Application No: LU/163/20/PL
Site Address: 6 Selborne Place Selborne Road Littlehampton BN17 5NH
Description of works: Demolition of existing conservatory, single storey front & rear extensions & change of use from HMO (Sui Generis) to 5 No. flats (4 net) (C3 Dwelling house). This application affects the character & appearance of the Littlehampton Seafront Conservation Area & may affect the setting of a listed building. This application is not CIL Liable as flats in Zone 4 (Zero Rated).

Thank you for your internet representation made on 27th July 2020 which has been recorded as an objection with the comments as follows:

Proposed Second Floor Plan 1:50

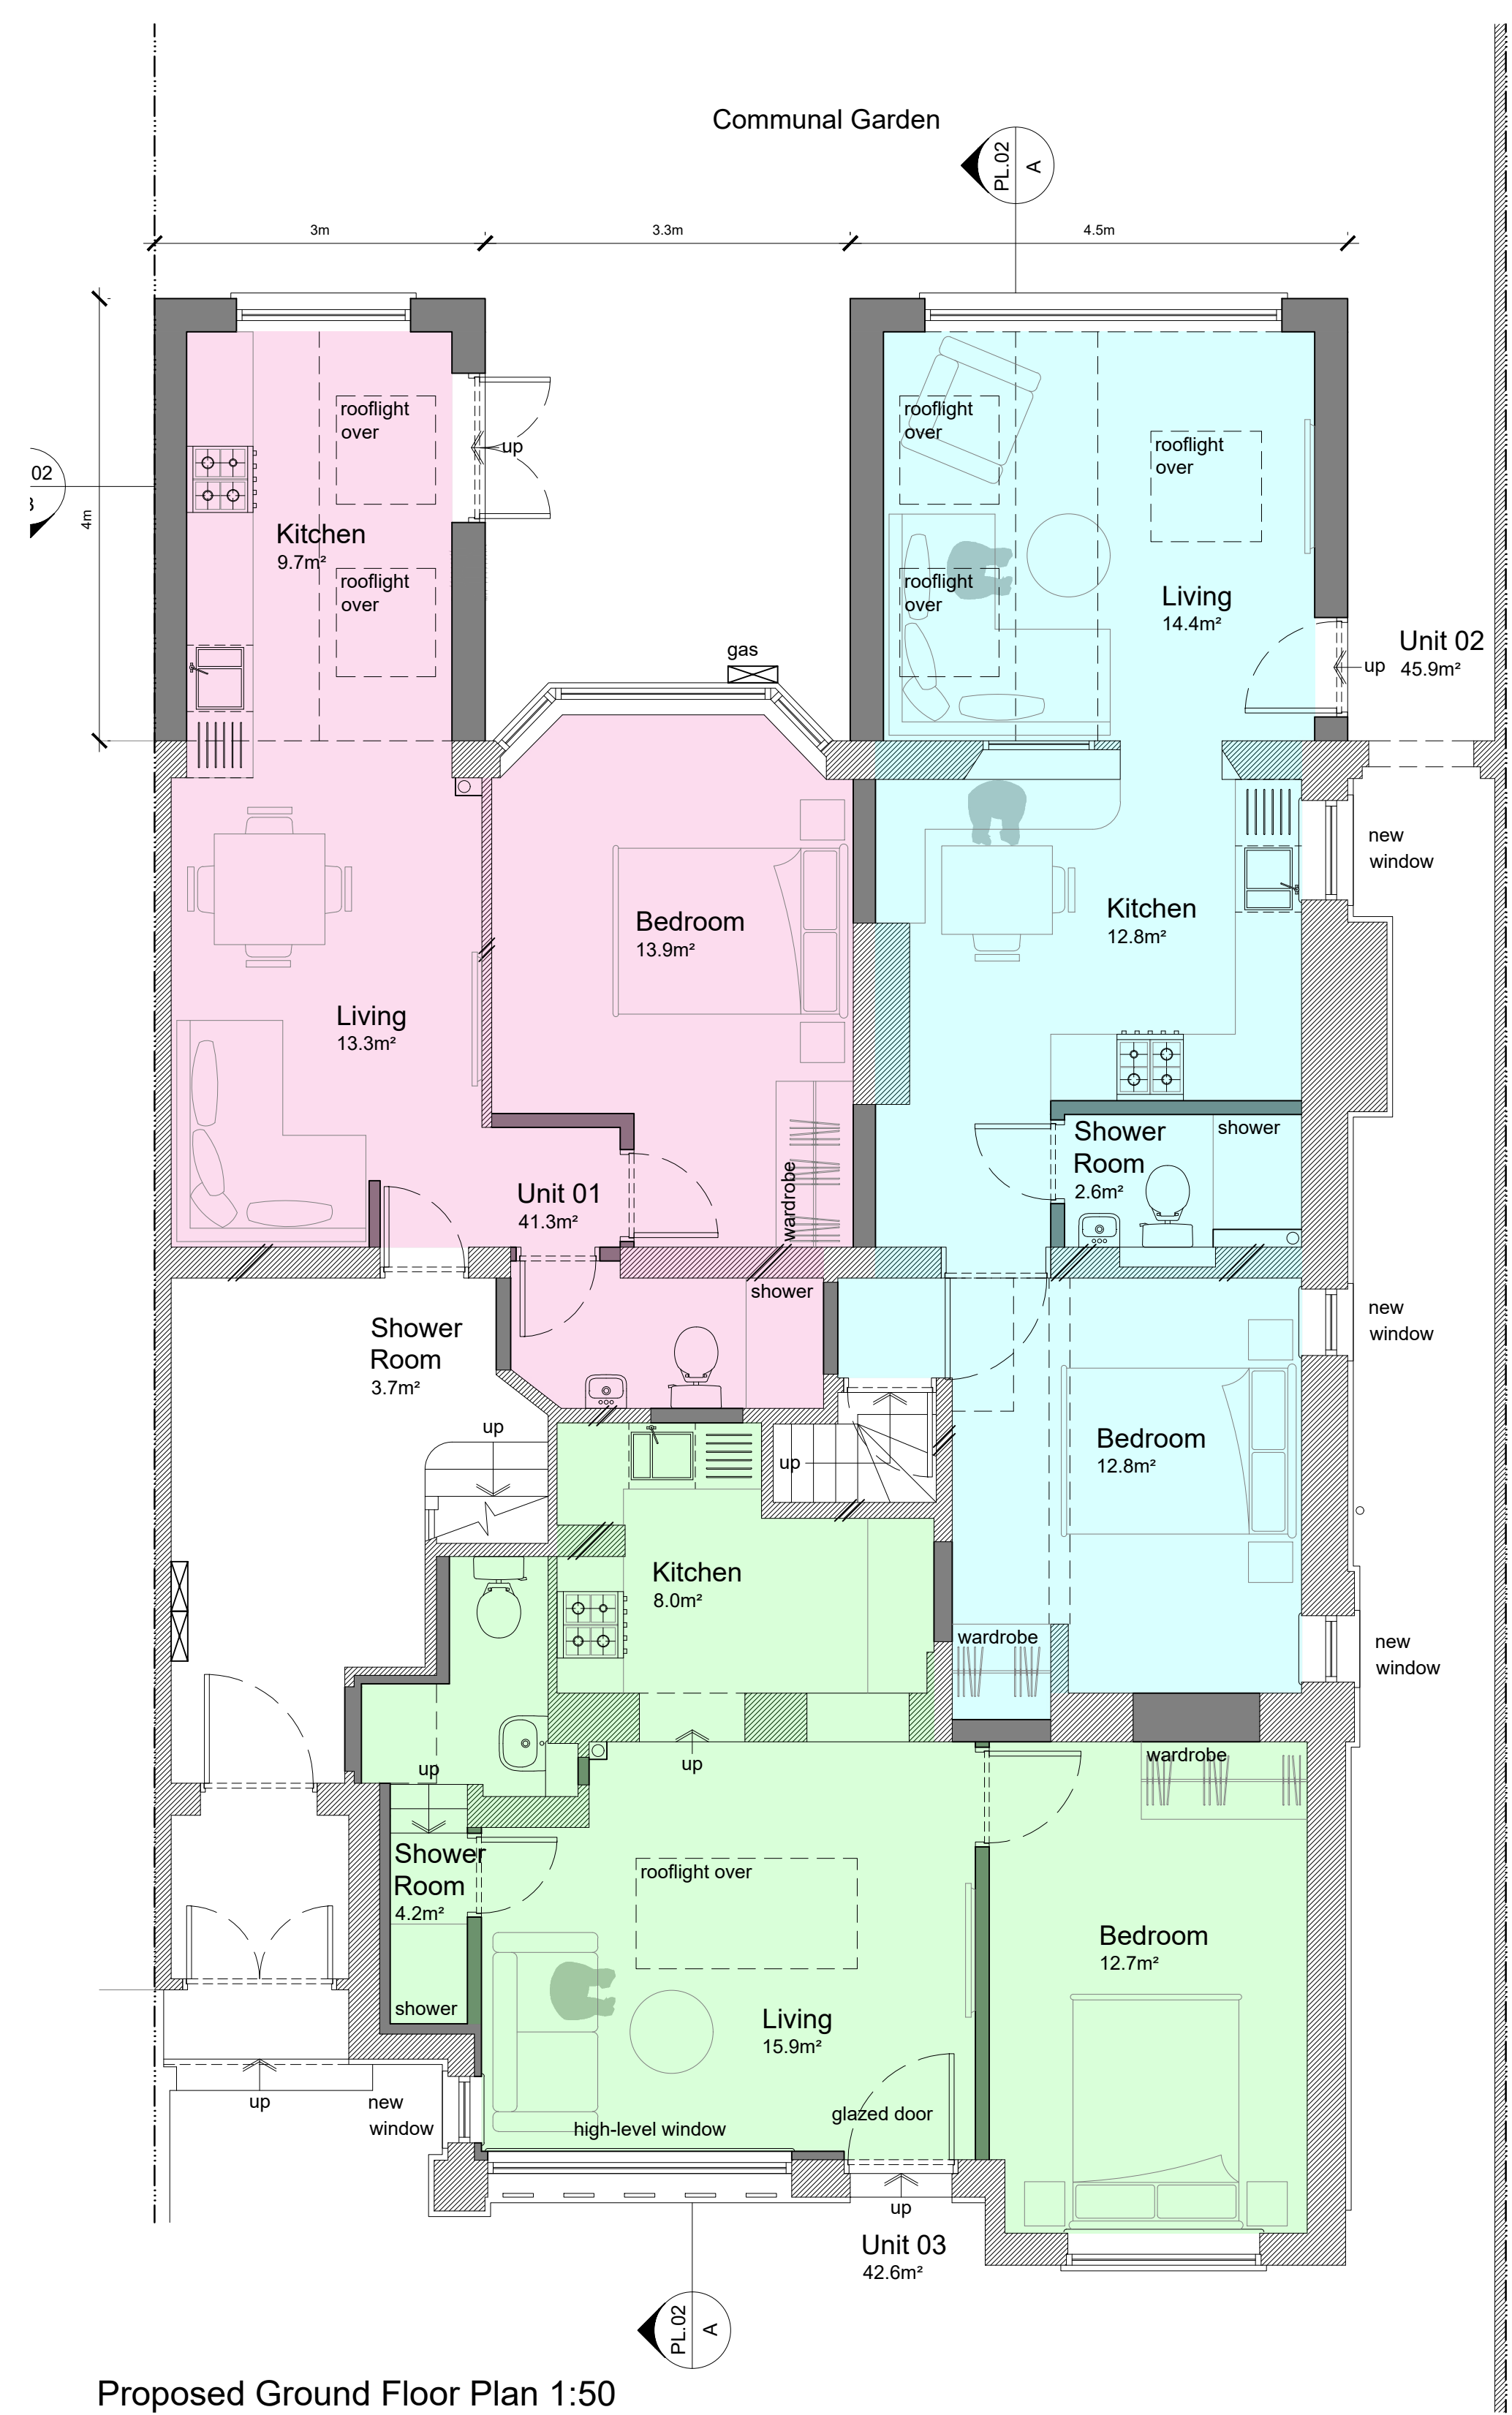
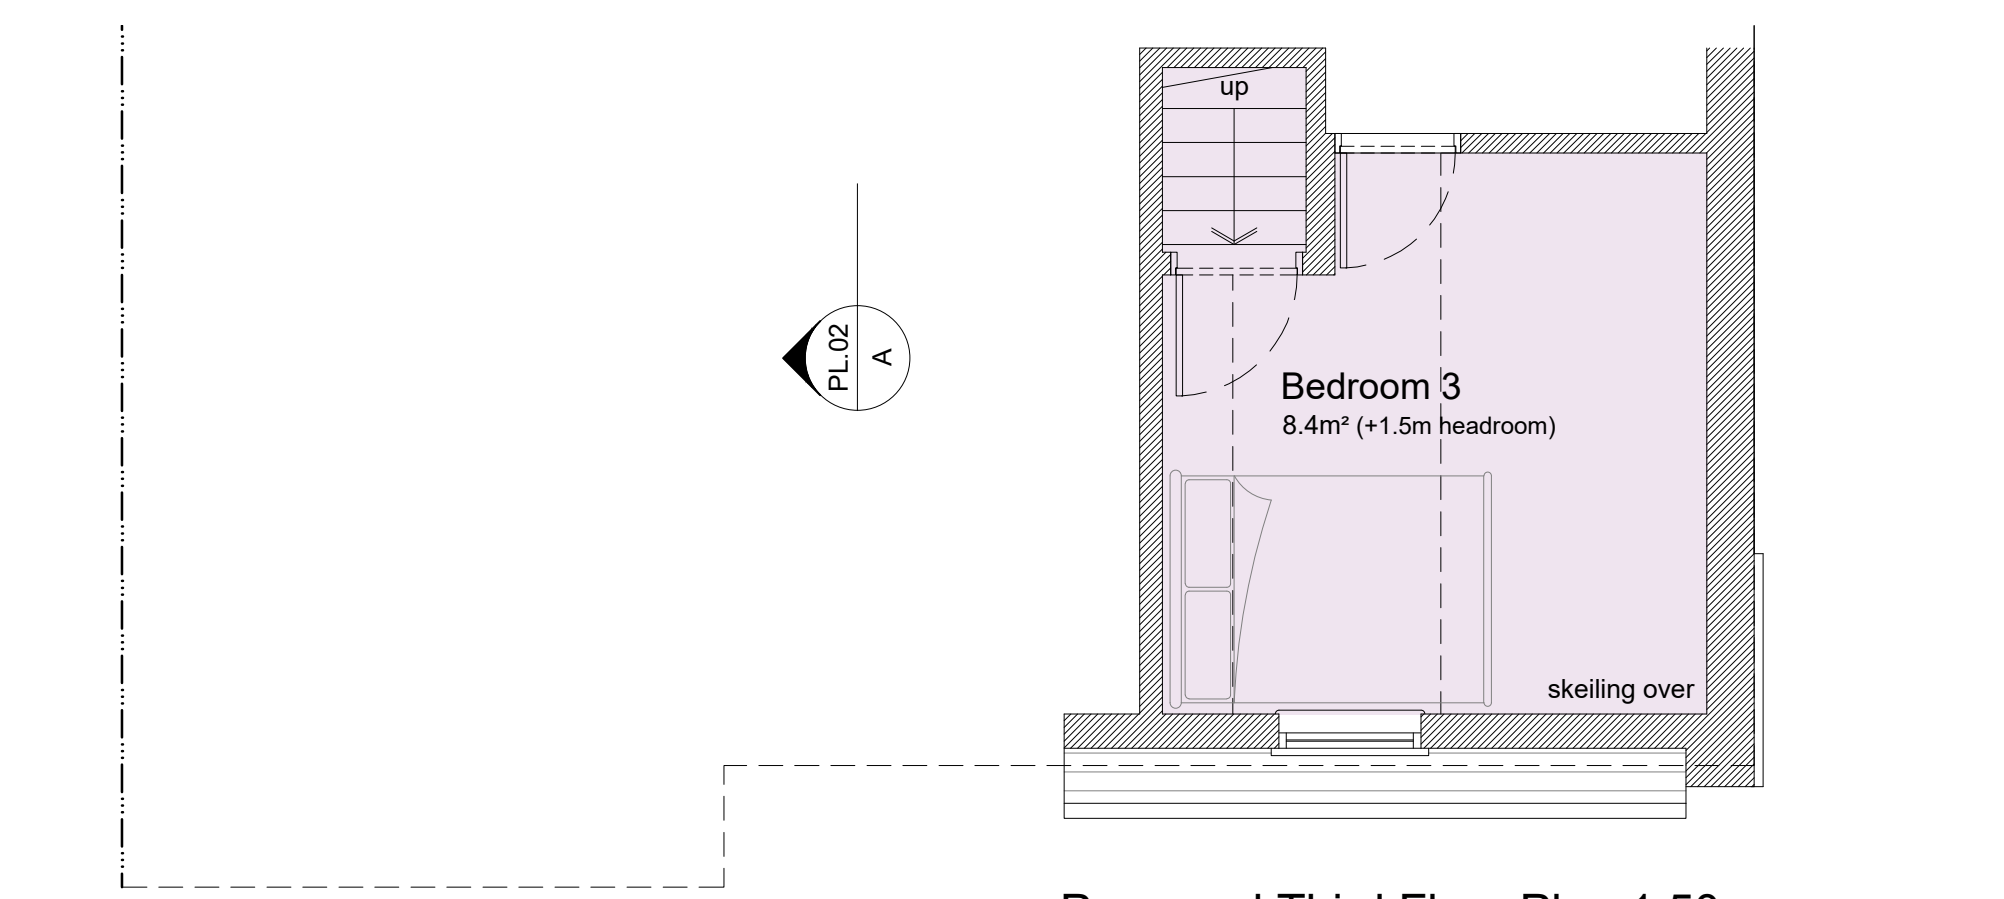
The Town Council's Planning and Transportation Committee considered this matter at its meeting held on Monday 20th July 2020 and objected to the application. Whilst the Committee welcomed the move to convert the premises from an HMO to a better standard of residential accommodation, there were significant concerns that some of the flats did not meet the minimum space standards (Policy DDM2 of the Arun Local Plan). However the Committee did also consider that the proposals were well presented and indicated that if the issues with the room sizes could be satisfactorily addressed they would be willing to reconsider their decision.
